Field Report

Project	Residential Structural Observation	Project No.	23-F025
Location	1185 Joe Collins Rd Lillington, NC 27546	Report No.	1
Client	Eunice Bucur	Day & Date	Tuesday, 04.18.23
Contact	eunicebucur@gmail.com	On-Site Time	1.00 hr
		Report Prep.	3.00 hr
		Travel Time	2.00 hr
		Total	6.00 hr

I arrived on site, as requested, to perform a Structural observation in accordance with 2018 North Carolina State Residential Code. This observation pertains to existing LVL framing and other framing concerns raised by an AHJ inspection. Structural Observation does not include or waive the responsibility for the inspections required by other sections of the building code.

FIRST FLOOR PLAN

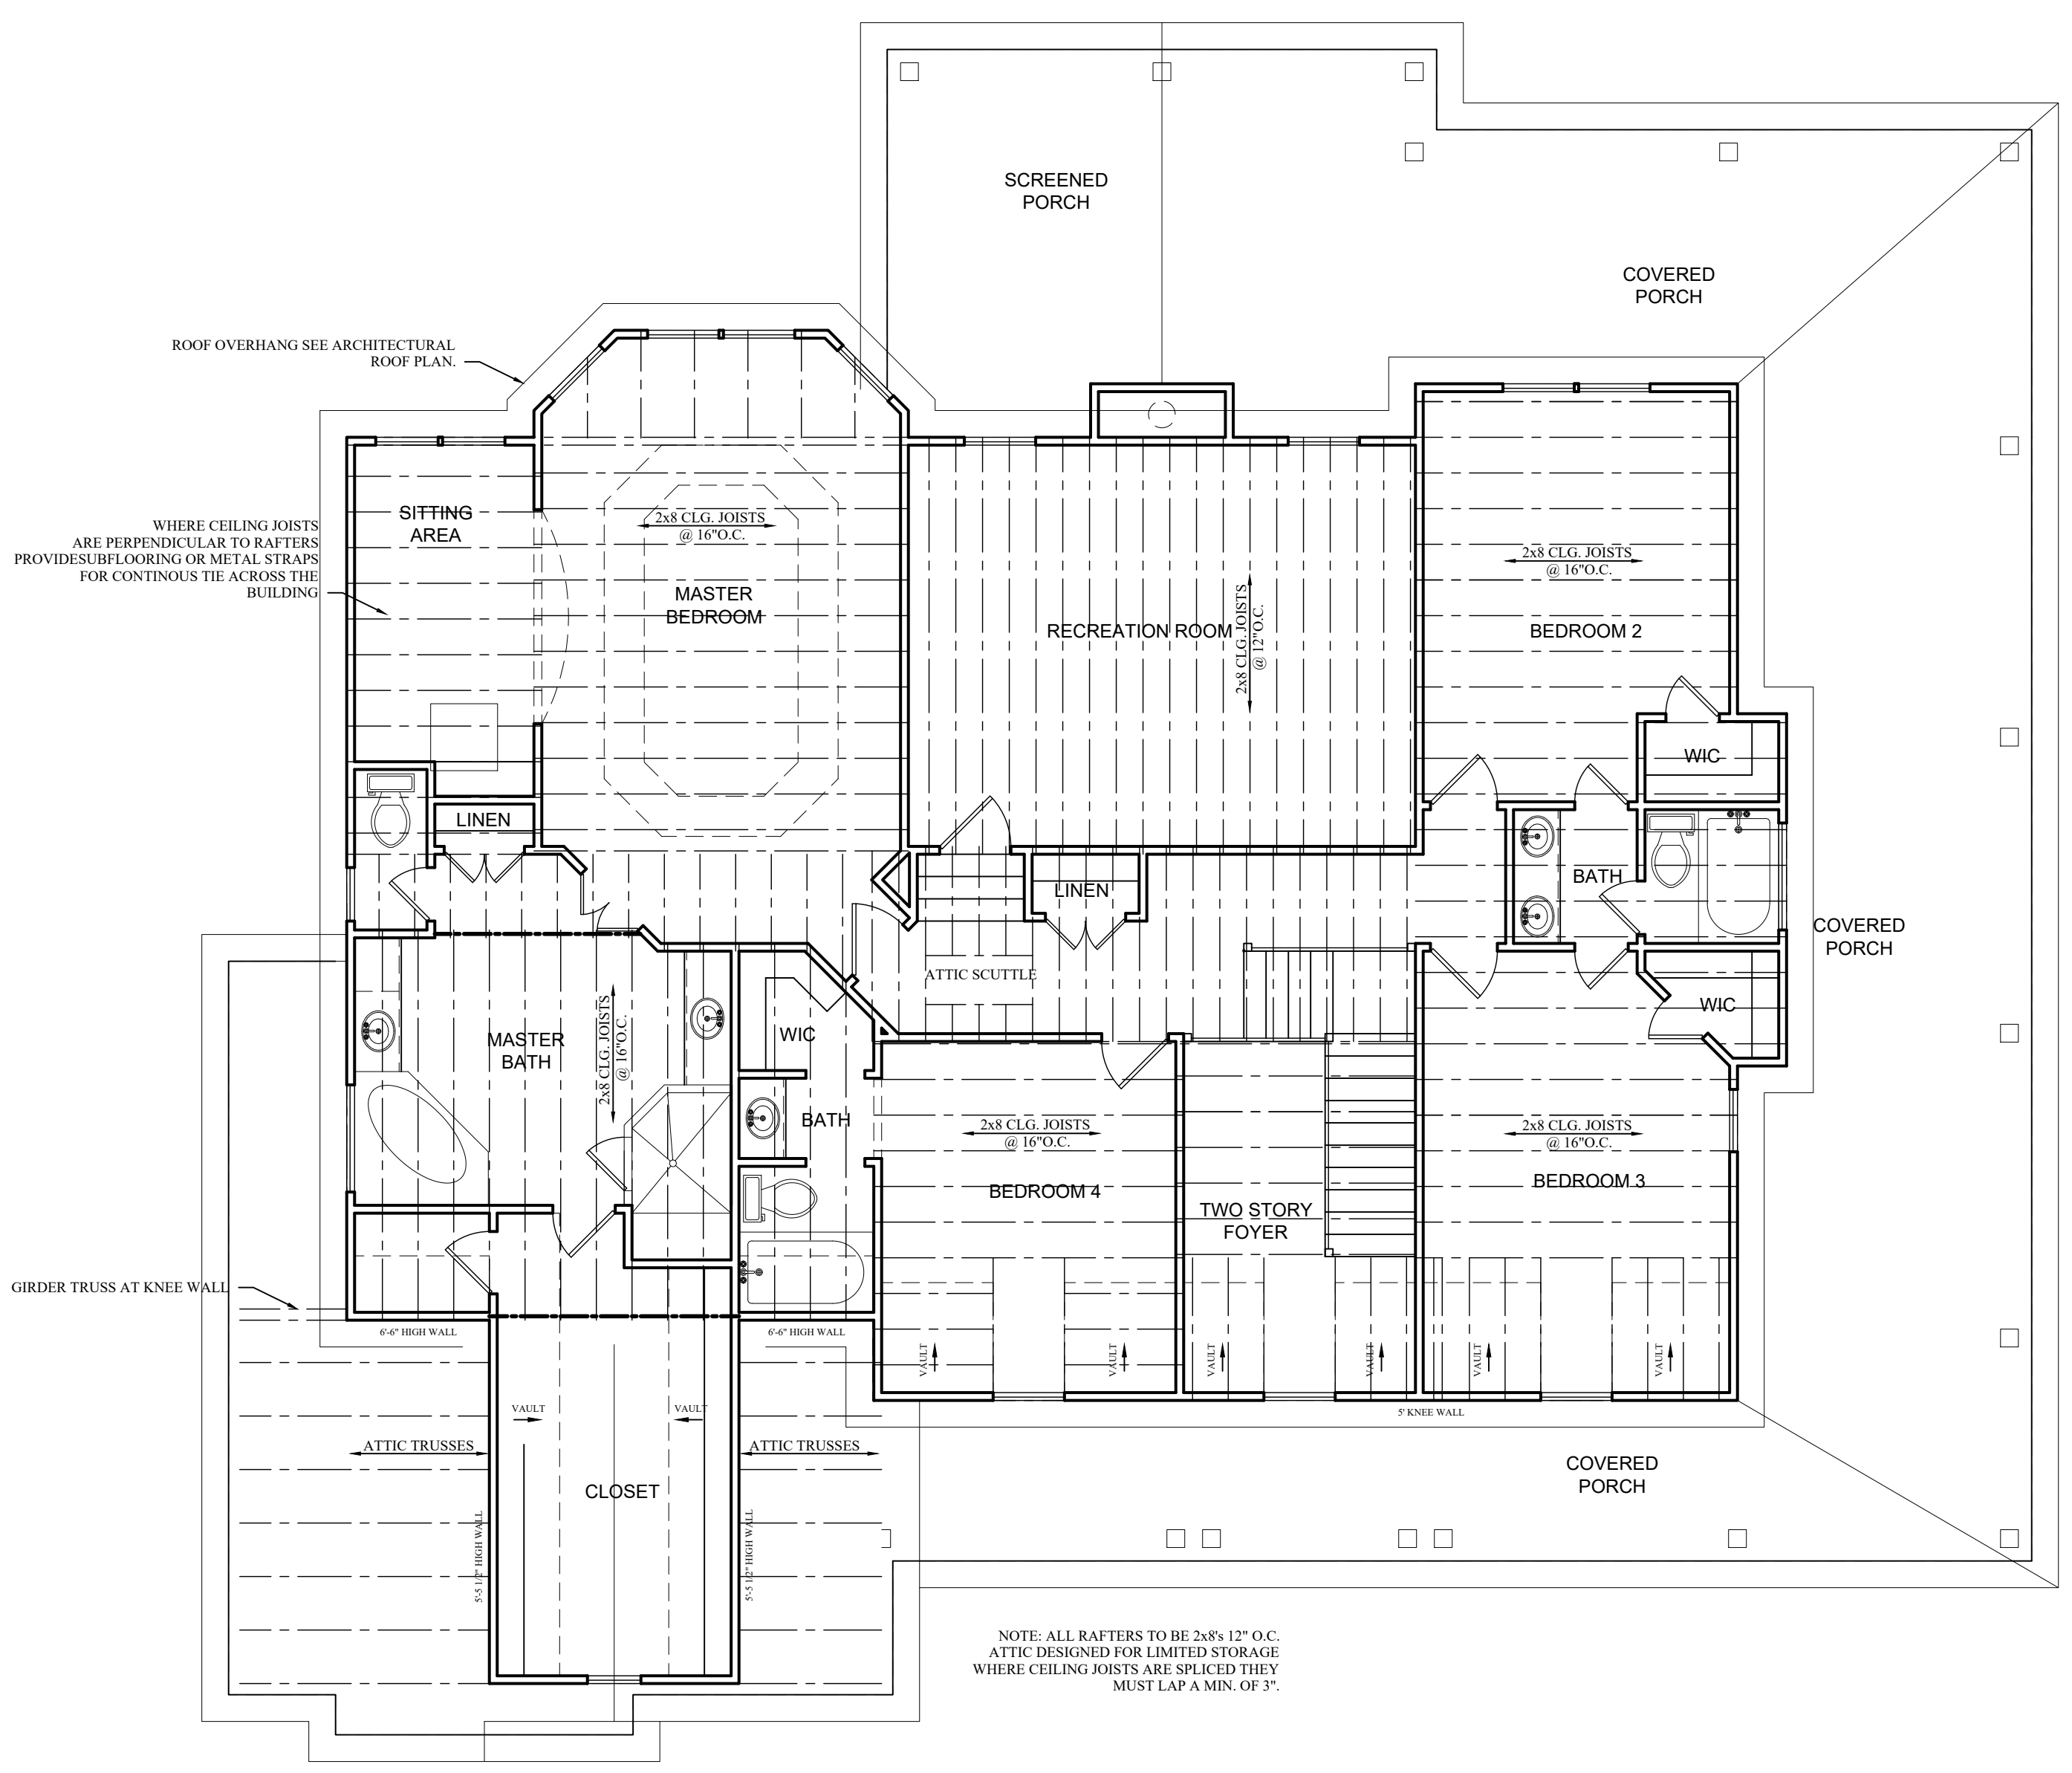
- a. Beam B2 = 4-ply 11⅞" LVL supported by minimum 4 ~ 2 x 4 jack studs each end.
- b. Beam B3 = 4-ply 11⅞" LVL supported by minimum 5 ~ 2 x 4 jack studs at one end and 4 ~ 2 x 8 jack studs on the other end..
- c. Garage girder = 3-ply 24" LVL supported by minimum 4 ~ 2 x 4 jack studs each end.
- d. Garage Beam 1 = 3-ply 9¼" LVL supported by minimum 4 ~ 2 x 4 jack studs at one end and Simpson Strong Tie "HU610" face-mount hanger at supporting 24" LVL.
- e. Garage Beam 2 = 2-ply 9¼" LVL supported by minimum 3 ~ 2 x 4 jack studs at one

- end and Simpson Strong Tie “HU410” face-mount hanger at supporting 24” LVL.
- f. Garage door header = 2-ply 24” LVL supported by minimum 3 ~ 2 x 4 and 4 ~ 2 x 4 jack studs (7 ~ total) each end.
- g. Notched header at 2-story foyer shall be acceptable as observed. No additional repair shall be required.
- h. Notched header at Living Room/Optional Bedroom 6 shall be acceptable as observed. No additional repair shall be required.
- i. Notched header at Bedroom 5/Study shall be acceptable as observed. No additional repair shall be required.

SECOND FLOOR PLAN
 3/16"=1'-0"

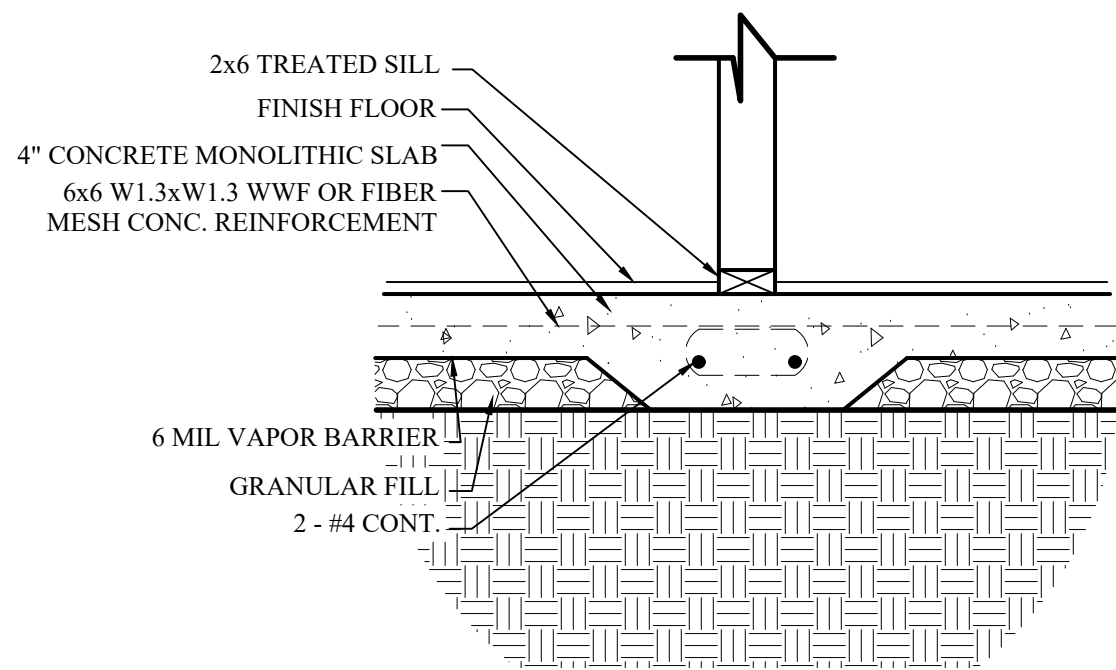
- a. Beam B4 at top of 2-story foyer = 2-ply 9¼” LVL supported by minimum 3 ~ 2 x 4 jack studs at each end.
- b. Beam B5 between master bedroom and hallway = 2-ply 11⅞” LVL supported by minimum 3 ~ 2 x 4 jack studs at each end
- c. Beam B6 between master bedroom and sitting area = 2-ply 9¼” LVL supported by minimum 3 ~ 2 x 4 jack studs at each end
- d. Beam B7 between master bath and hallway = 2-ply 9¼” LVL supported by minimum 2 ~ 2 x 4 jack studs at each end.

BASEMENT PLAN

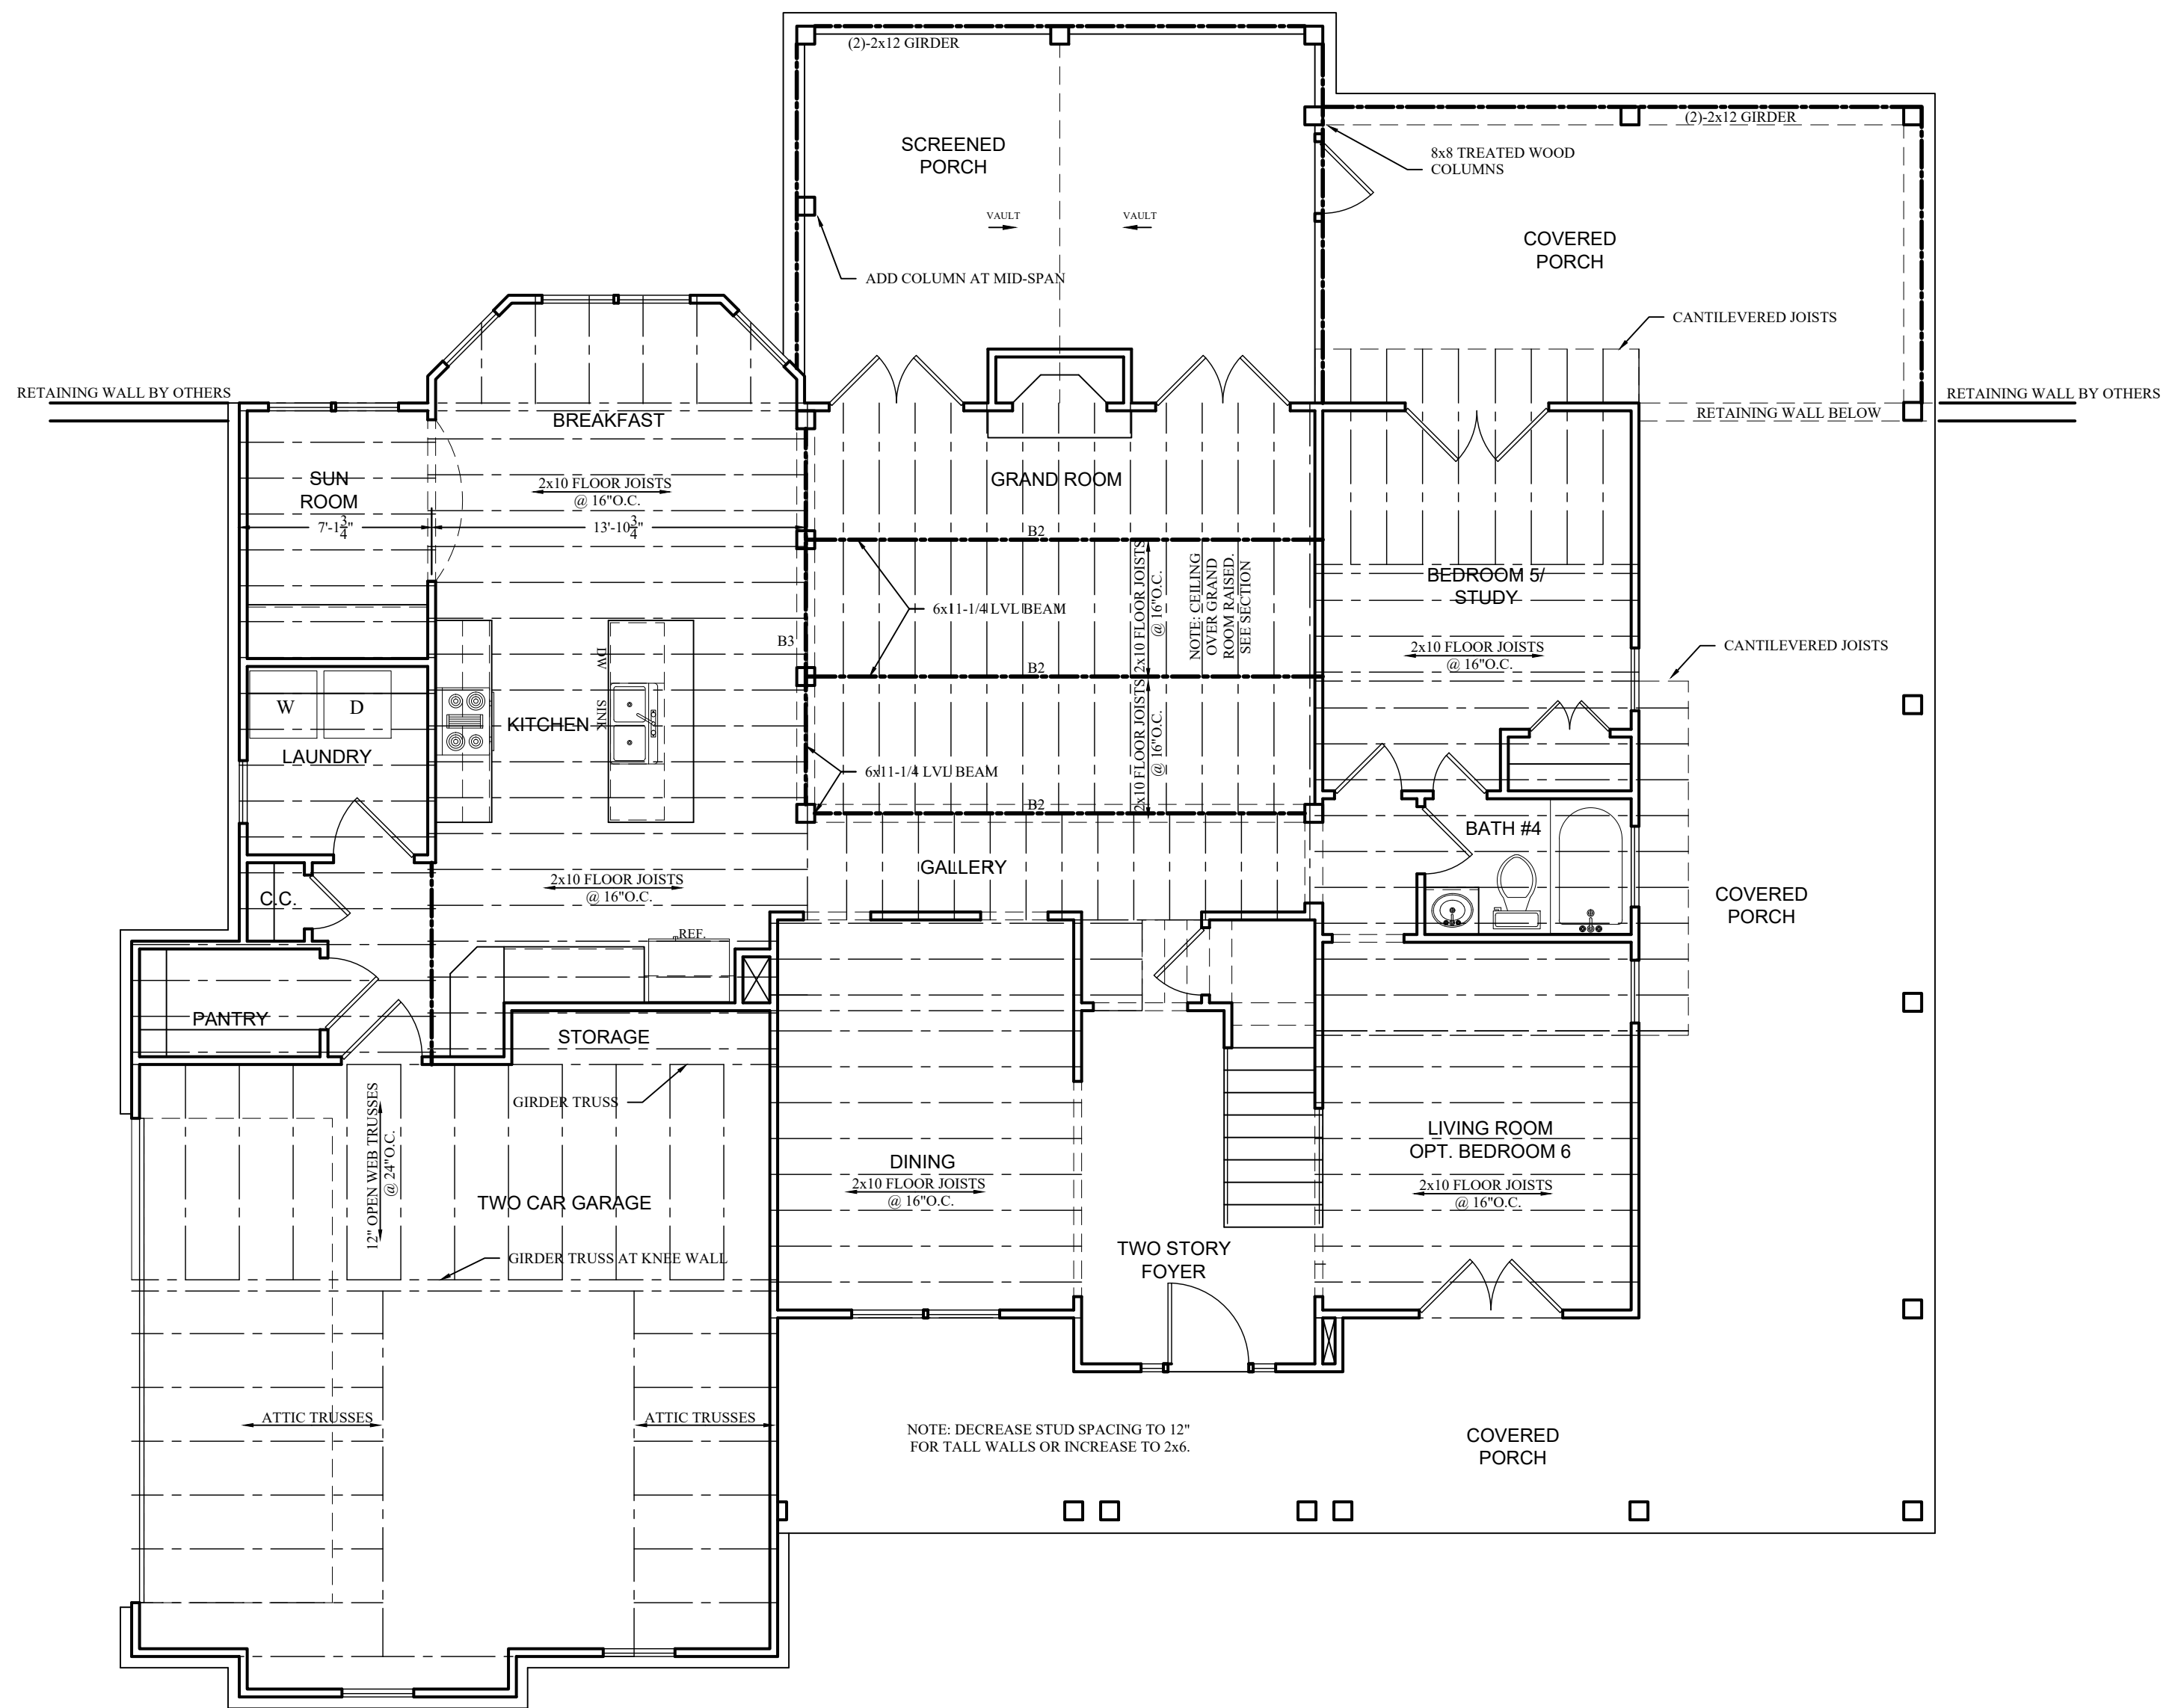
- a. Beam B1 = 3-ply 16" LVL supported by minimum 4 ~ 2 x 4 jack studs each end.
- b. Attach double PT 2 x 12 deck joists on either side of the cantilevered chimney to the ledger with Simpson Strong Tie "LS50" angle, using 4 ~ 8d x 1½" nails into the ledger and 4 ~ 8d common nails into the double joist.
- c. Notched joists to allow plumbing penetration shall be acceptable as observed. No additional repair shall be required.
- d. Observed toenailed connection between header and floor joist by plumbing penetrations shall be adequate.
